**MECKLENBURG COUNTY**  
**Land Use & Environmental Services Agency**

**MEMORANDUM**

To: Charlotte-Mecklenburg Planning Commission  
From: LUESA, Mecklenburg County  
Date: 7.27.23  
Subject: Rezoning Petition Comments

**2023-031: Crescent - Carson & S. Tryon**

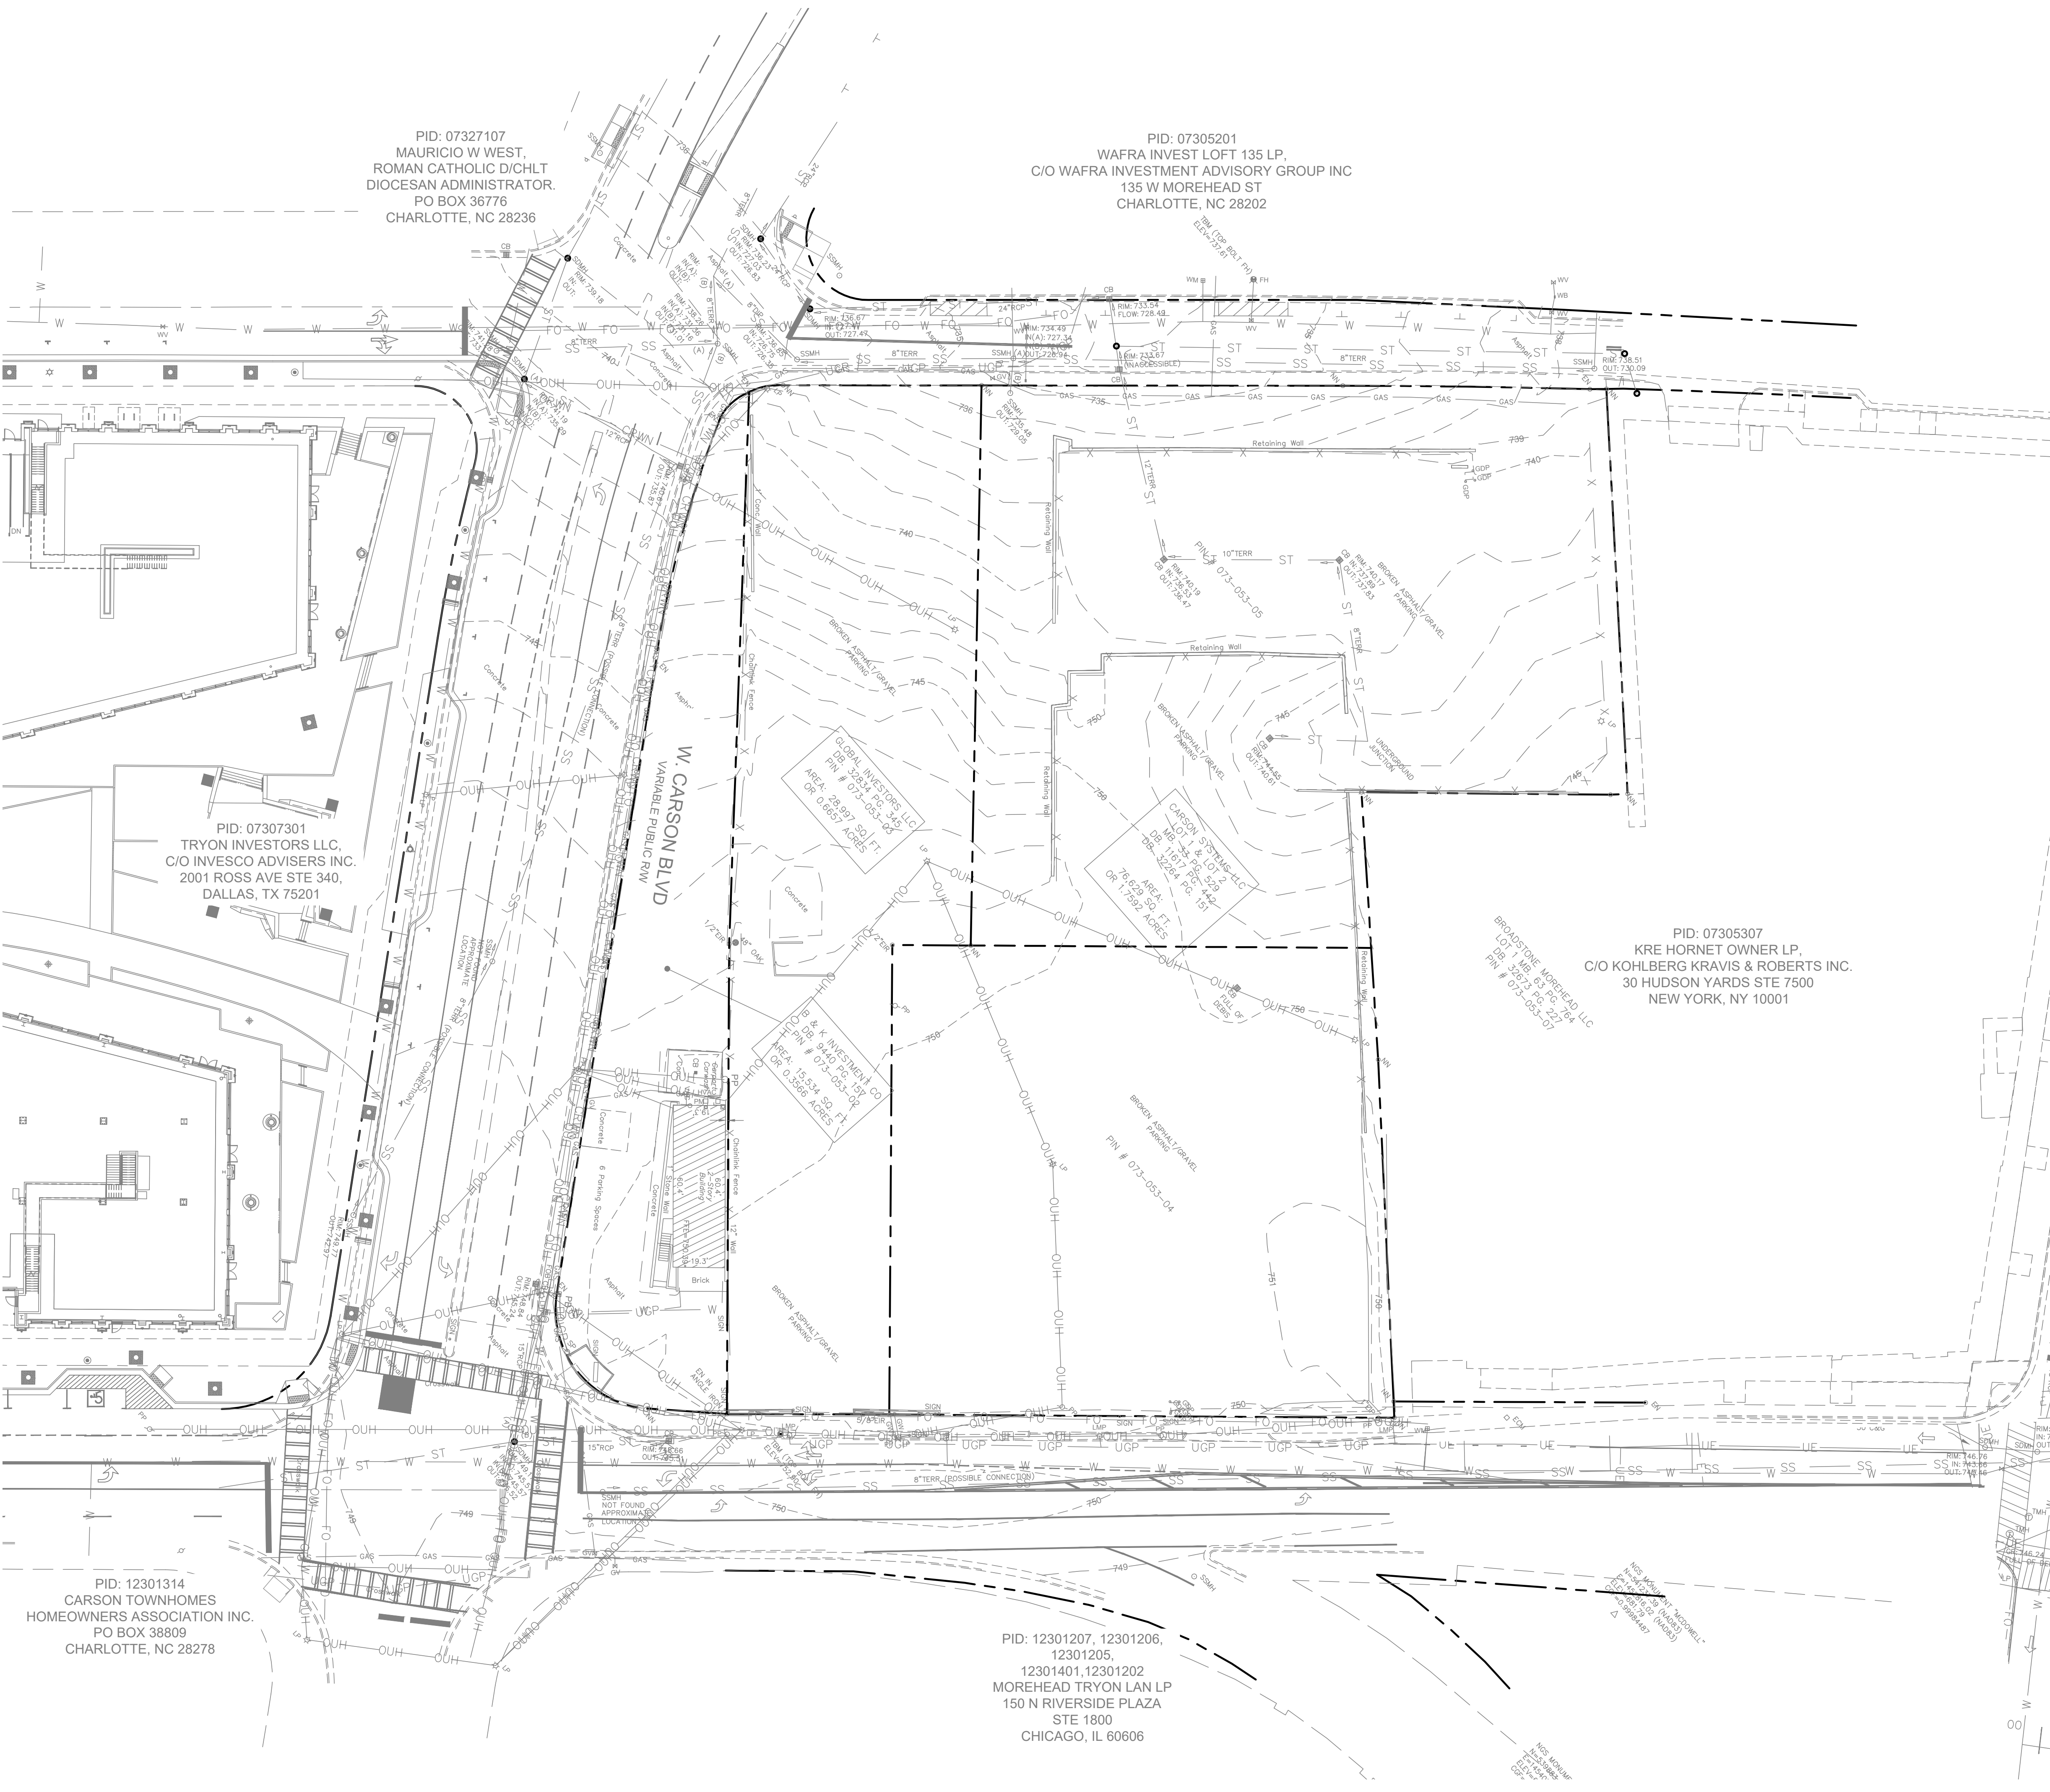
Groundwater & Wastewater Services records indicate a Subsurface Investigation Permit (SIP) was issued for parcels 073-053-04 and 073-053-05. Please note that monitoring wells on this parcel need to be located, flagged and protected prior to development or be permanently abandoned in accordance with the Mecklenburg County Groundwater Well Regulations.
